2021/61/91506/W - Reserved Matters application for residential development at location Shop Lane, Kirkheaton, Huddersfield, HD5 0DB

**SHOP LANE**

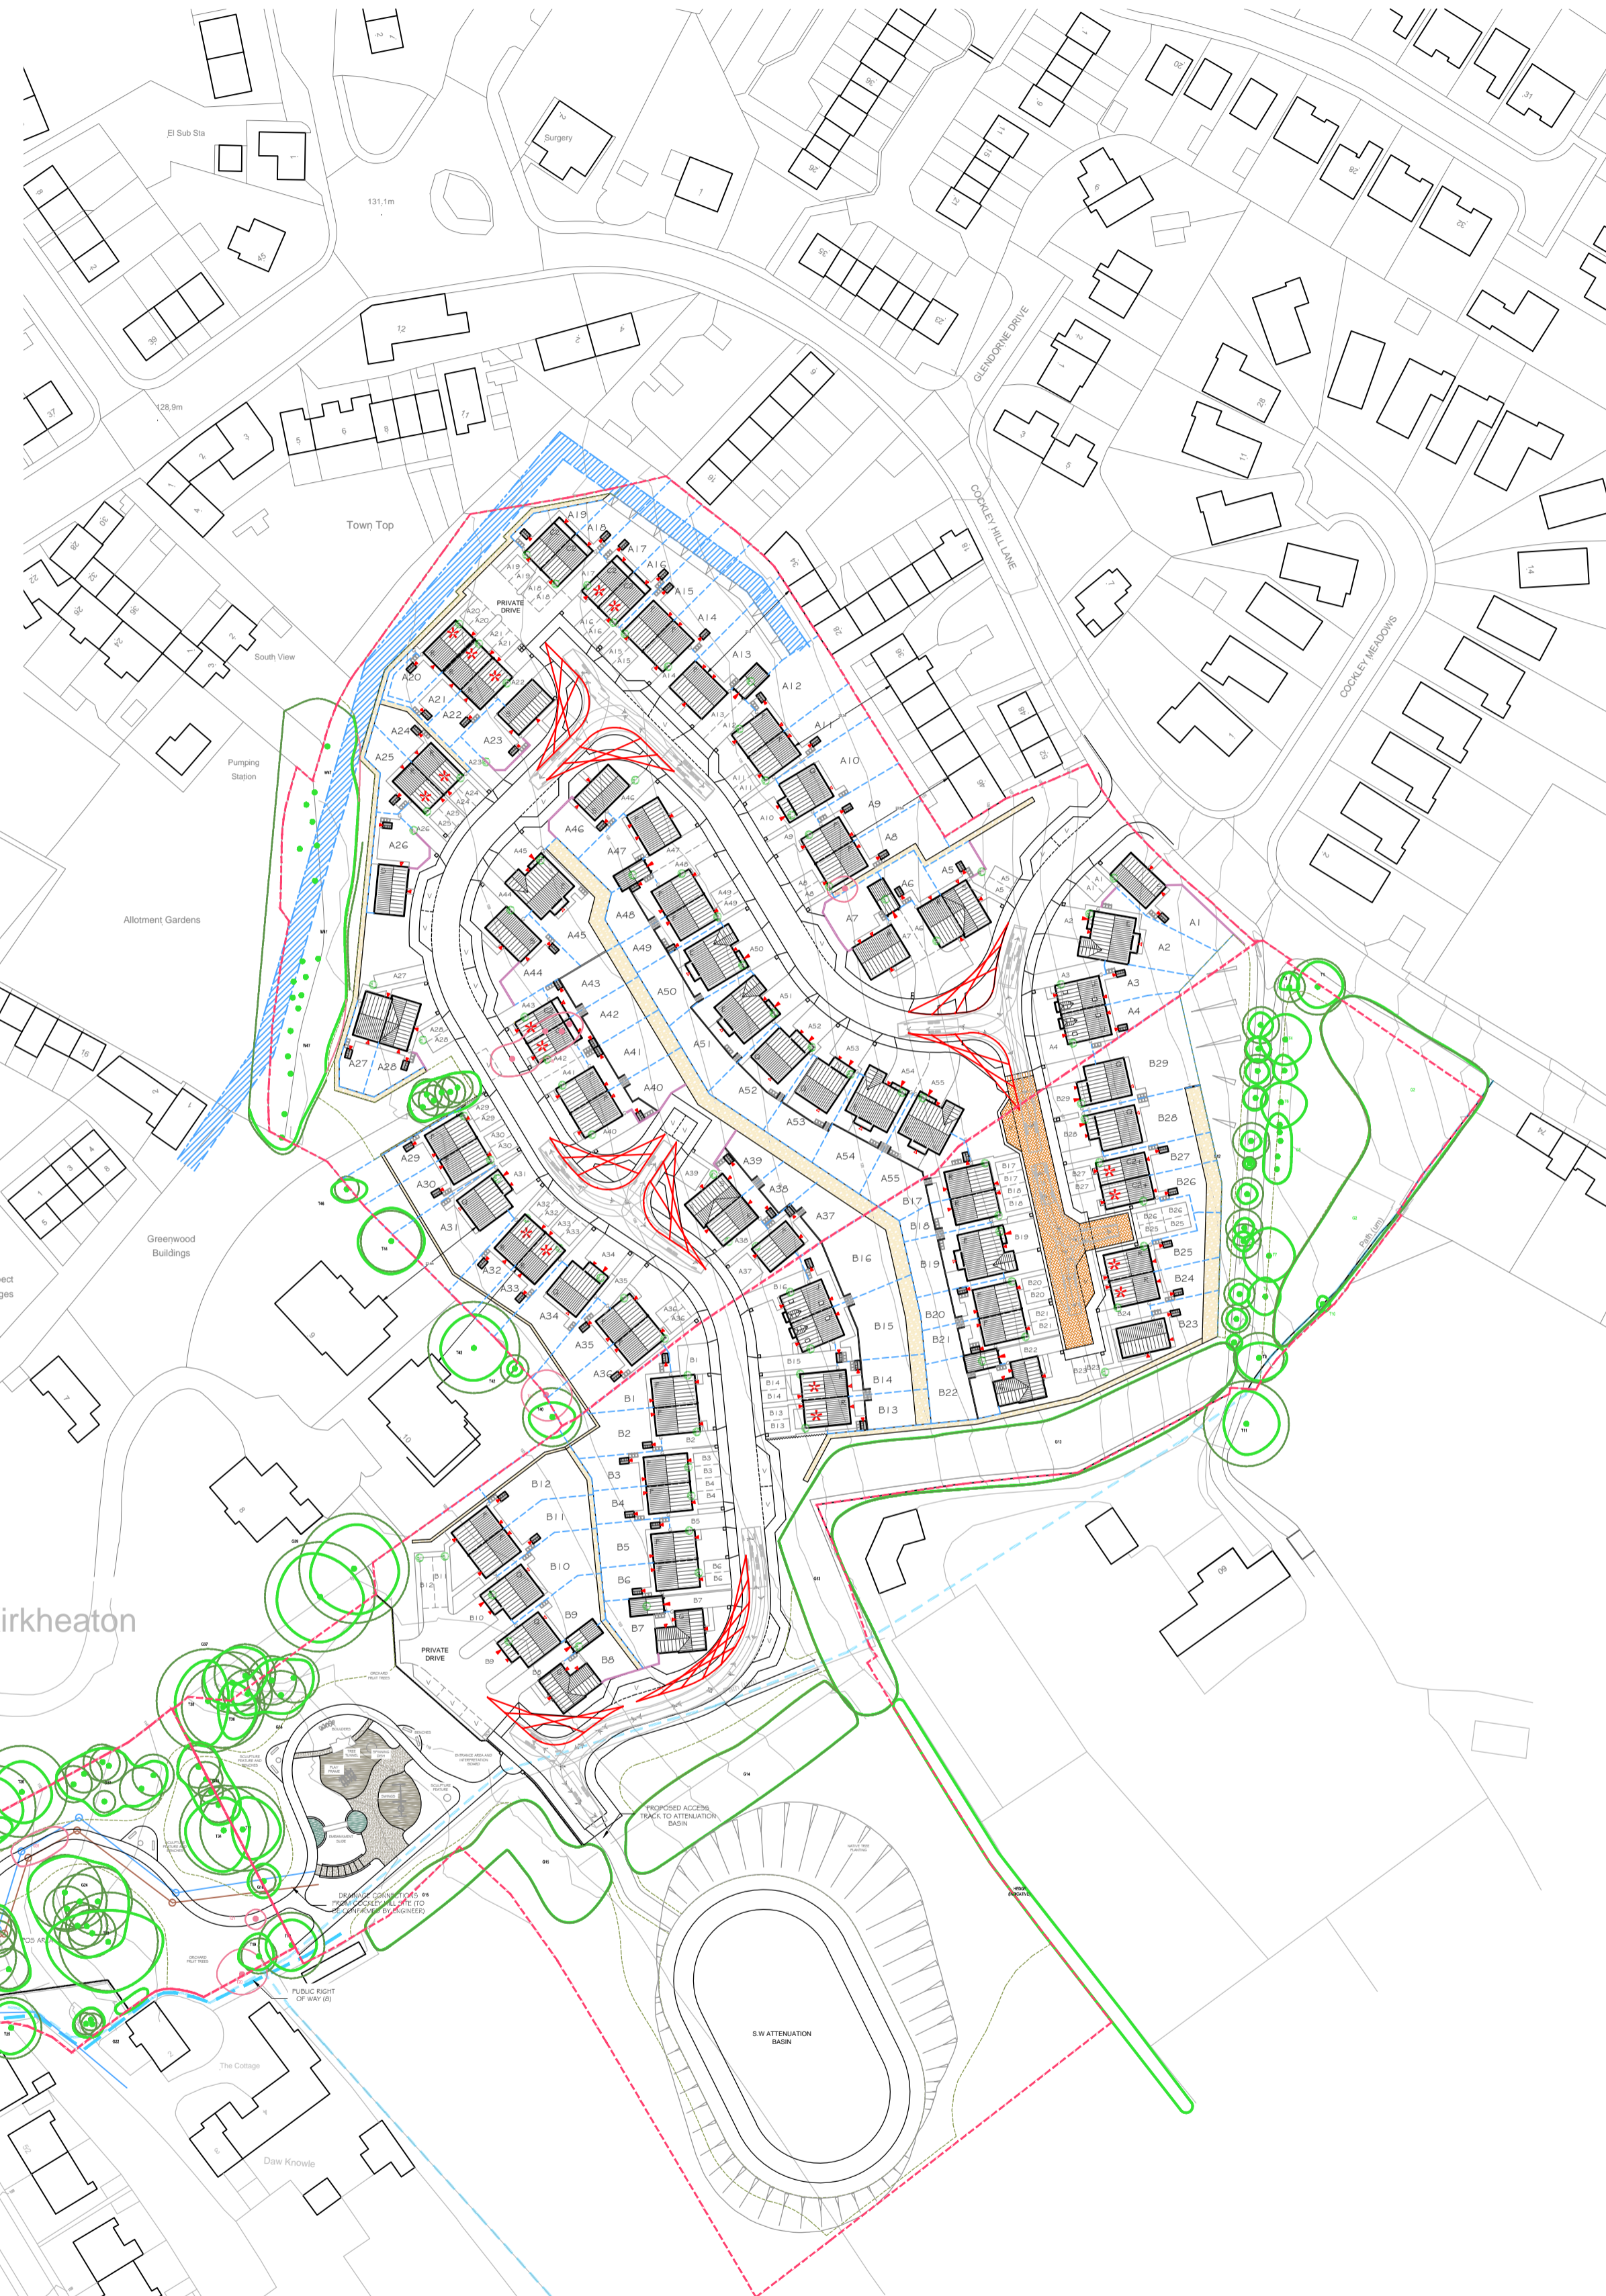
- There is limited parking, especially visitor parking which impacts on the ability for people with wheelchairs/mobility scooters, visual impairments and pushchairs to mobilise safely when cars are parked on the roadside.
- Some of the designs have door openings that impinge on each other which can impact on safe use of the home.
- Available storage is absent /minimal which can be an important feature for those living with disabilities and health needs.

Shop Lane is a busy road, often accessed by commuters as well as residents of Kirkheaton. The proposed access on Shop Lane for 48 households will create traffic congestion both on the site of the new development and on Shop Lane. Currently, it is very difficult to turn onto St Mary's lane from St Andrews Drive and I have no doubt the issue would be far greater at the new development as the plans stipulate one access unlike St Andrew's Drive. Adding additional access via Low Fold/Bankfield Lane may mitigate against increasing congestion on Shop Lane and would allow traffic to flow in and out of the new development with more ease. A designated cycle path through the development would be welcomed to ensure safety of cyclists and encourage cycling as an alternative method of transport. Residents need assurance that the vehicular access between 2 & 2a St Marys Lane will be unaffected by this development.
